STATE OF NORTH CAROLINA
DEPARTMENT OF TRANSPORTATION

Subject: **Supplementary Information for Nationwide Permit 23 and 33 Application.** Randolph County, Intersection Improvements to US 64/NC 49 and NC 42 in Asheboro, North Carolina, Federal Aid Project No. NHF 64(58), State Project No. 8.1572101, Division 8, WBS Element 34935.1.1, TIP Project No. U-3401.

Reference: May 24, 2005 Application for Nationwide Permit 23 and 33.

CULVERT CONSTRUCTION SEQUENCE STA. 30+24.5 -Y-

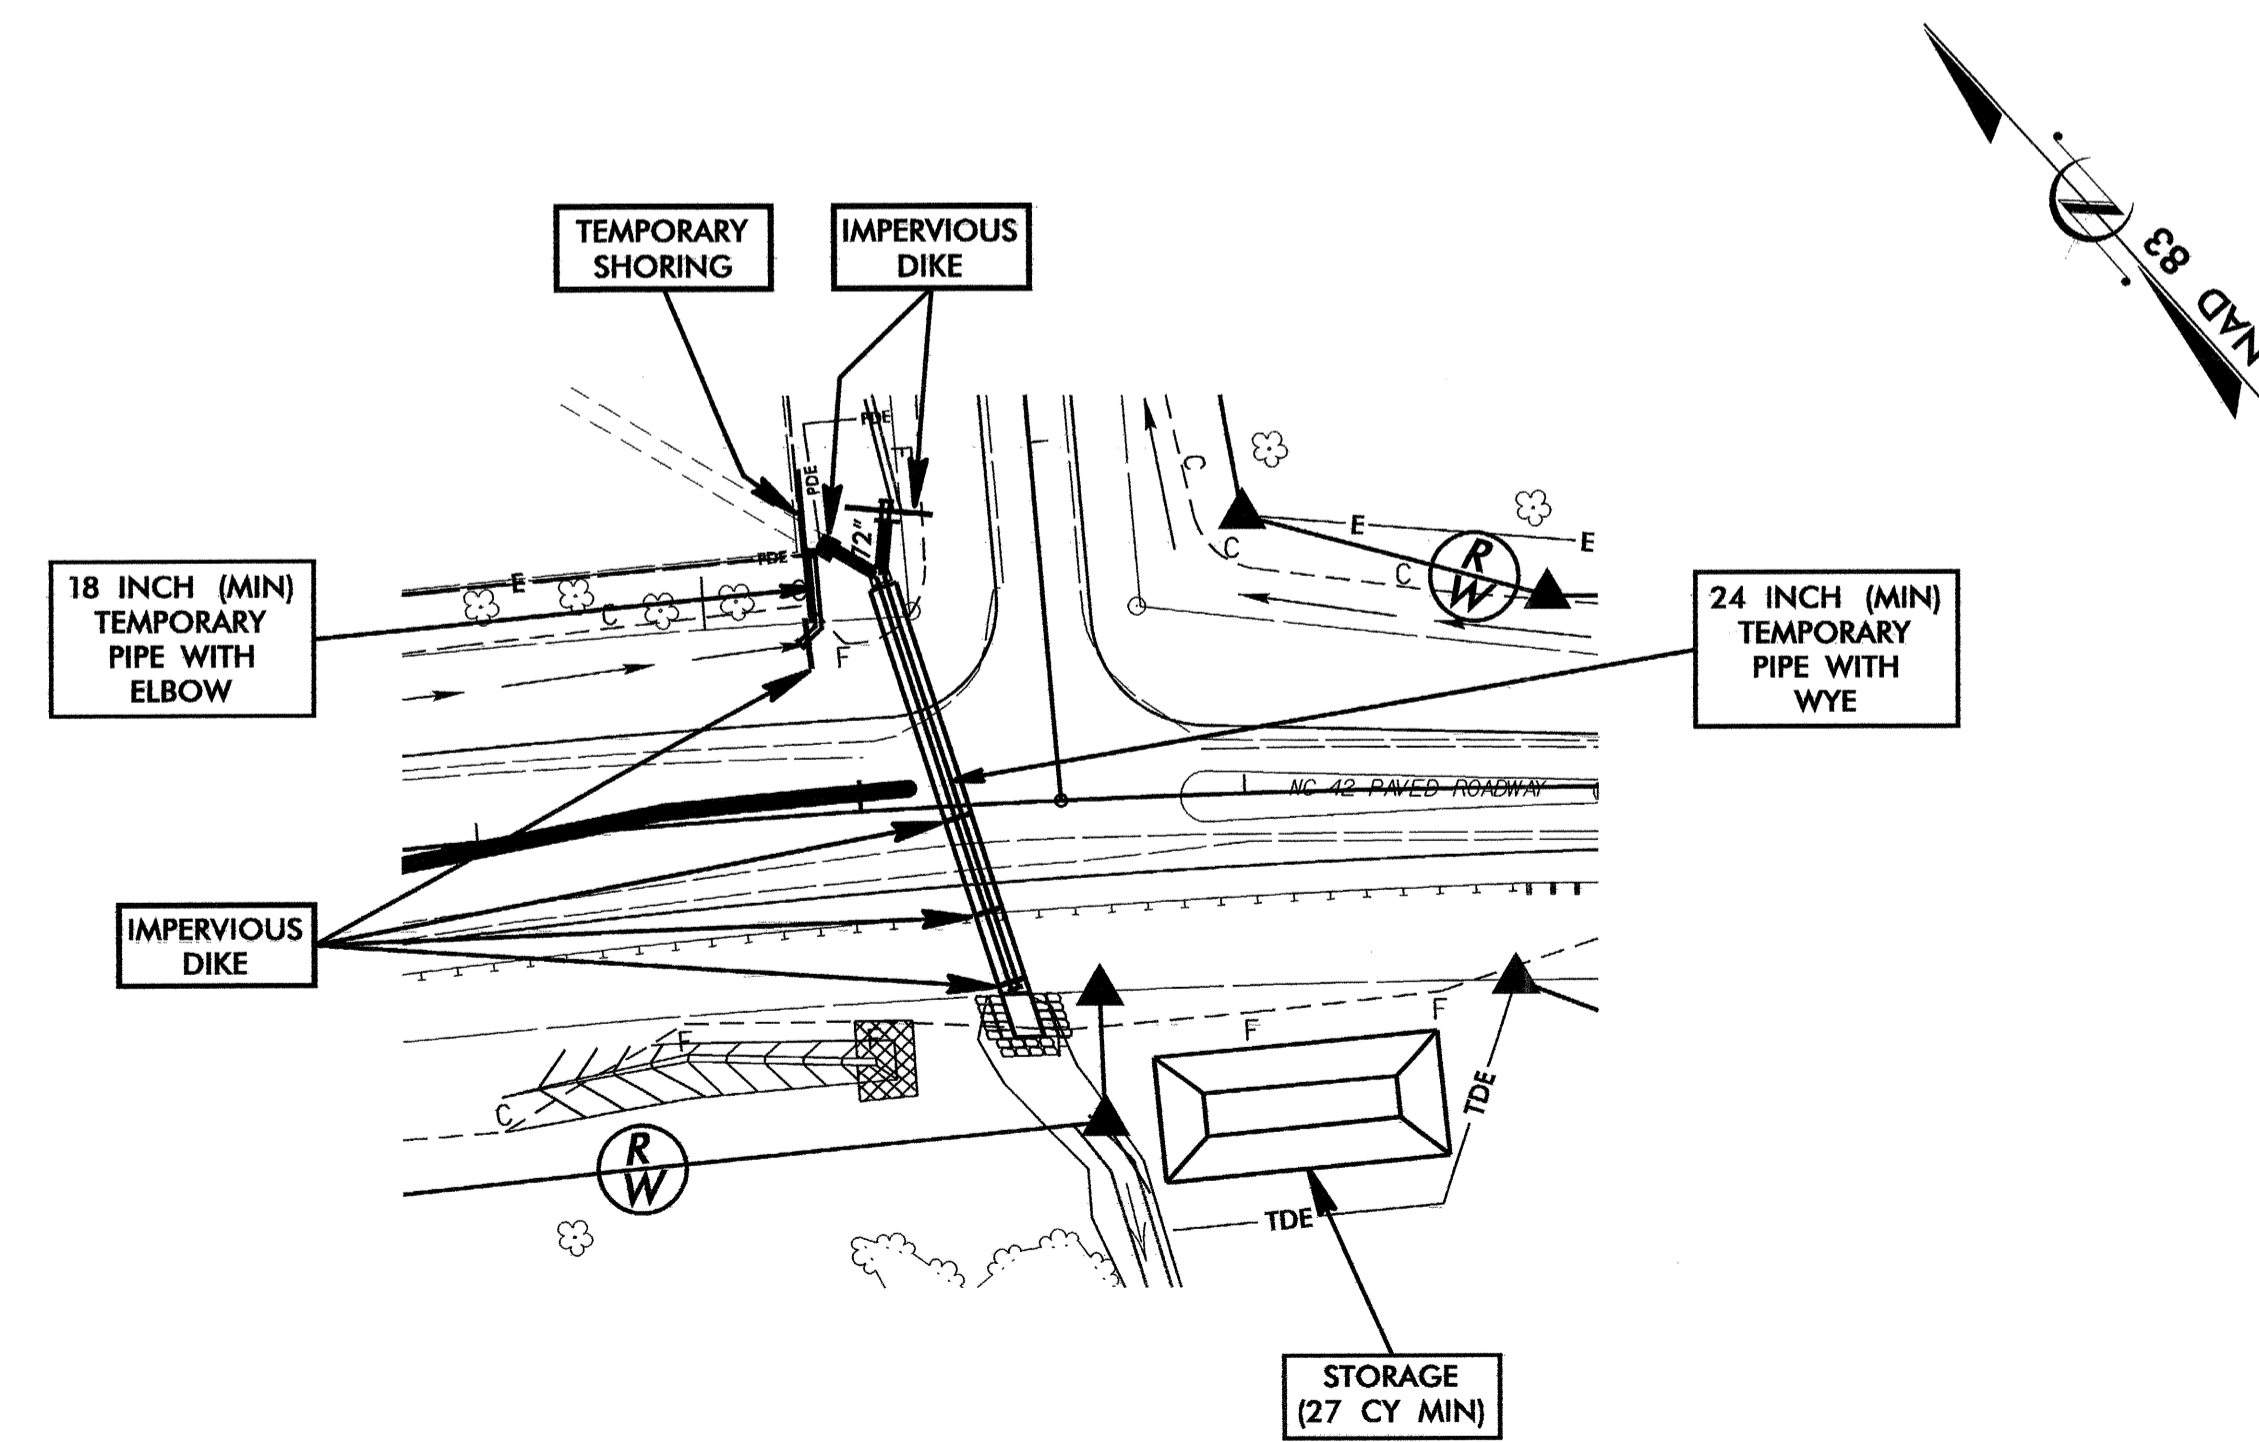
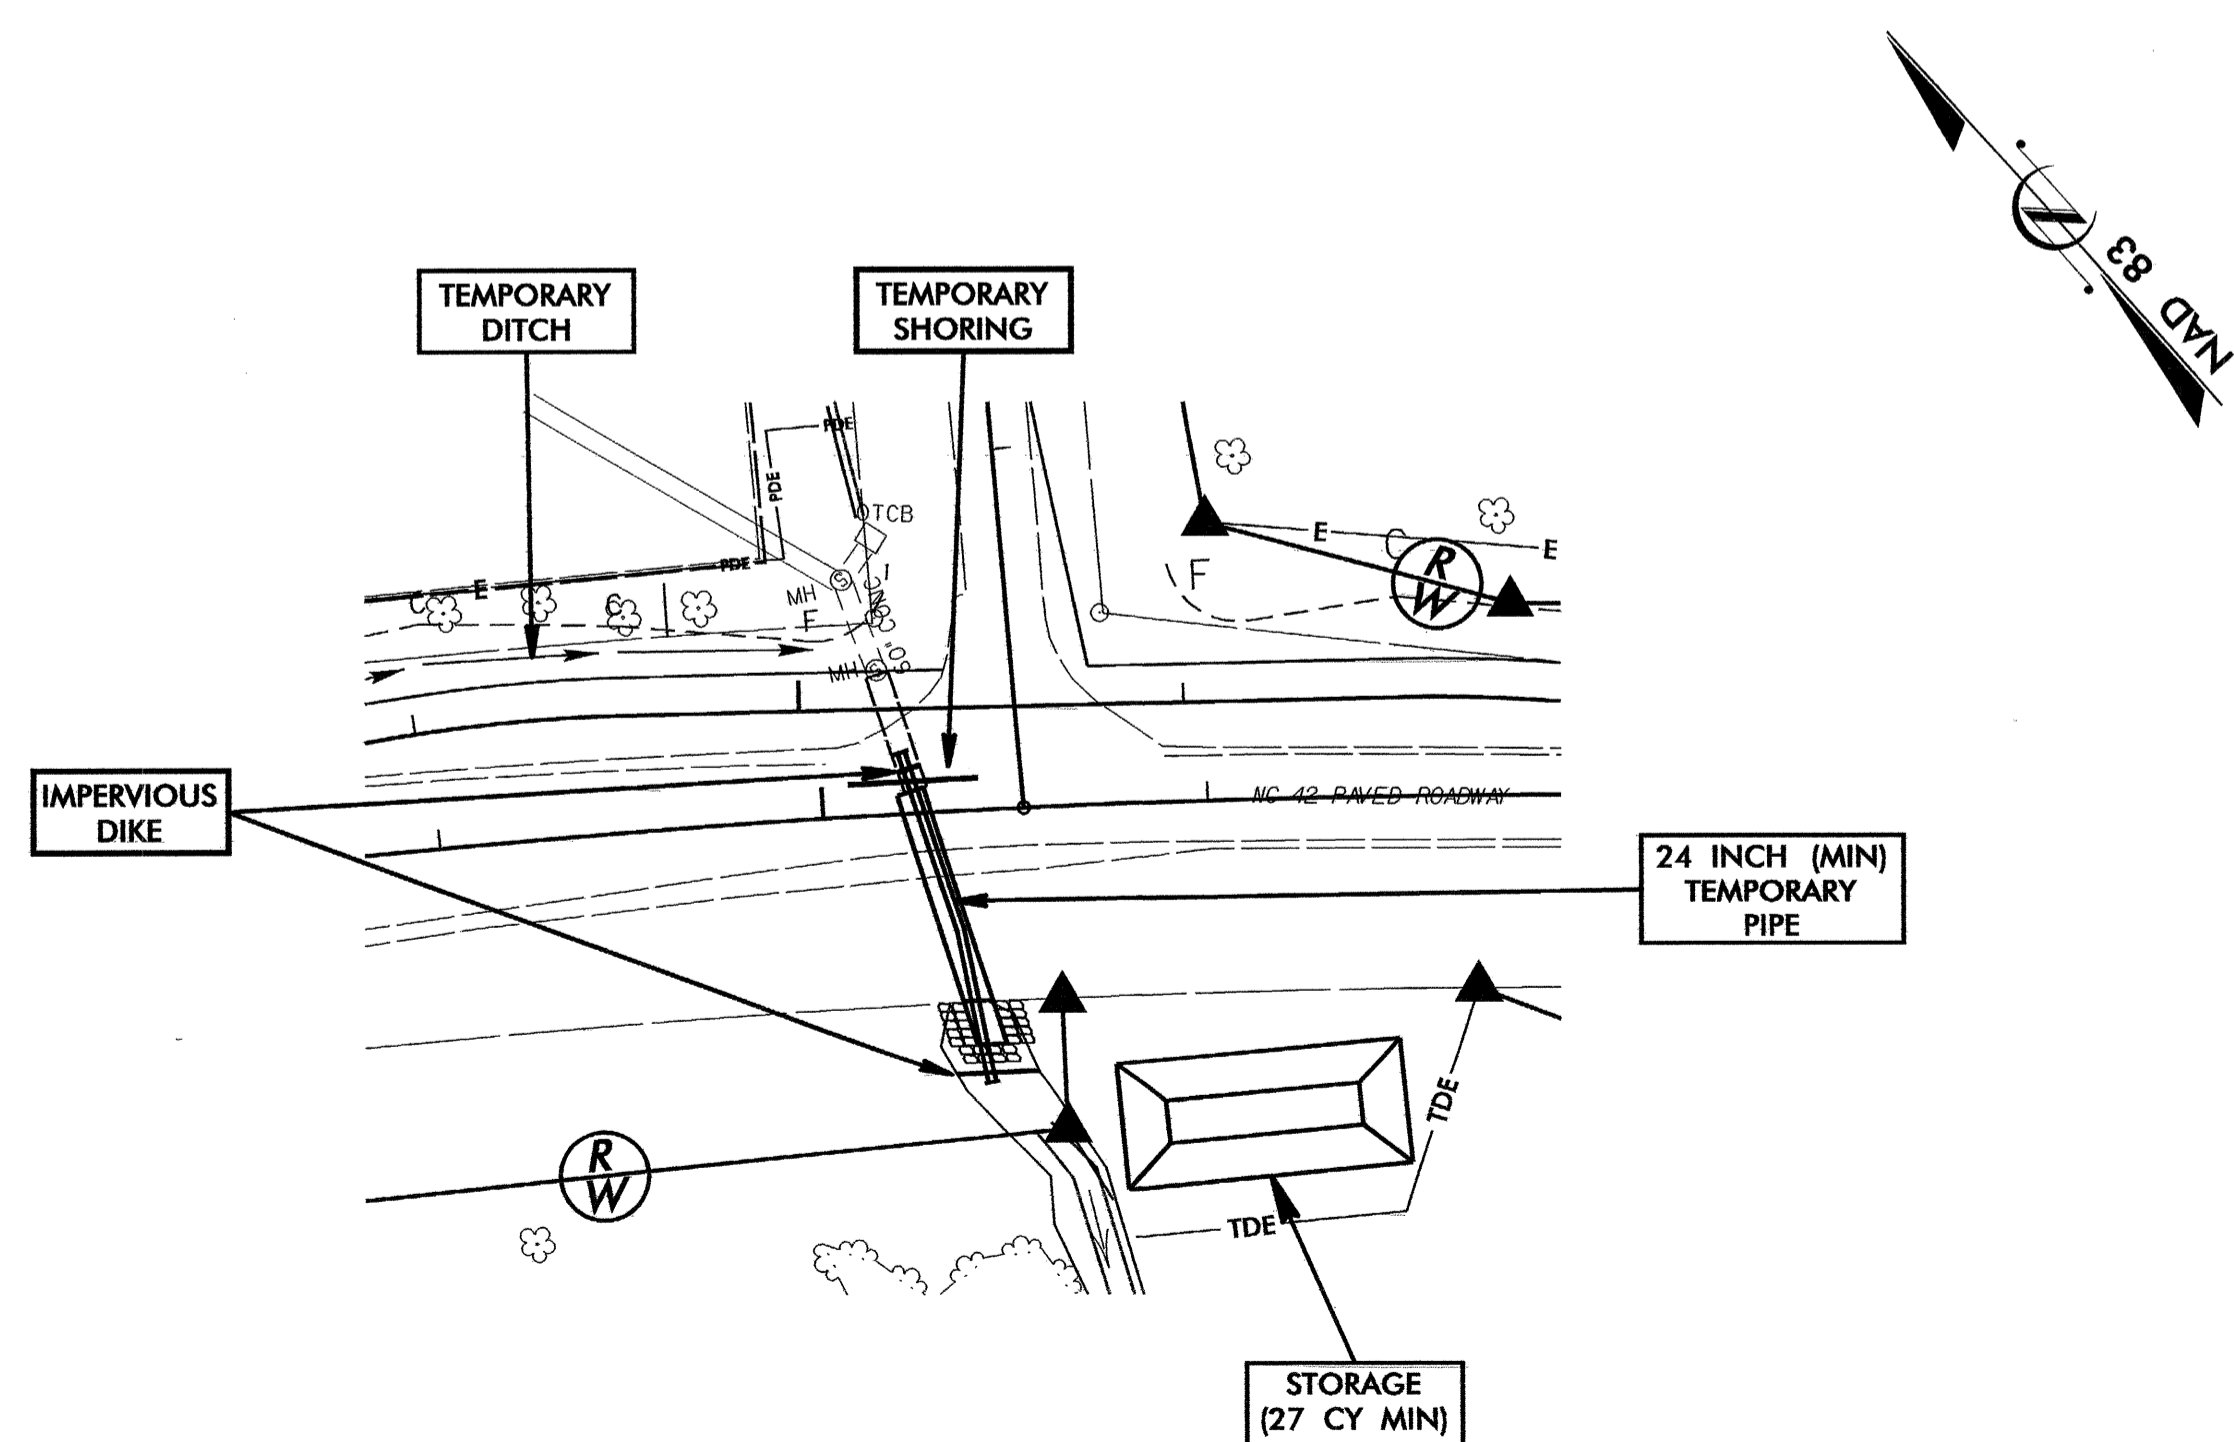
1. Increasing diversion pipe size from 18" to 24" in case of a major storm event. Using our design procedures with an urban discharge, the minimum required pipe size is 15". Due to the concerns, we feel that a 24" pipe would be appropriate. This has almost twice the cross-sectional area of an 18" (see drawings).
2. Impervious dikes will include two interior impervious dikes to serve as pipe support and as sediment reduction baffles (see drawings).
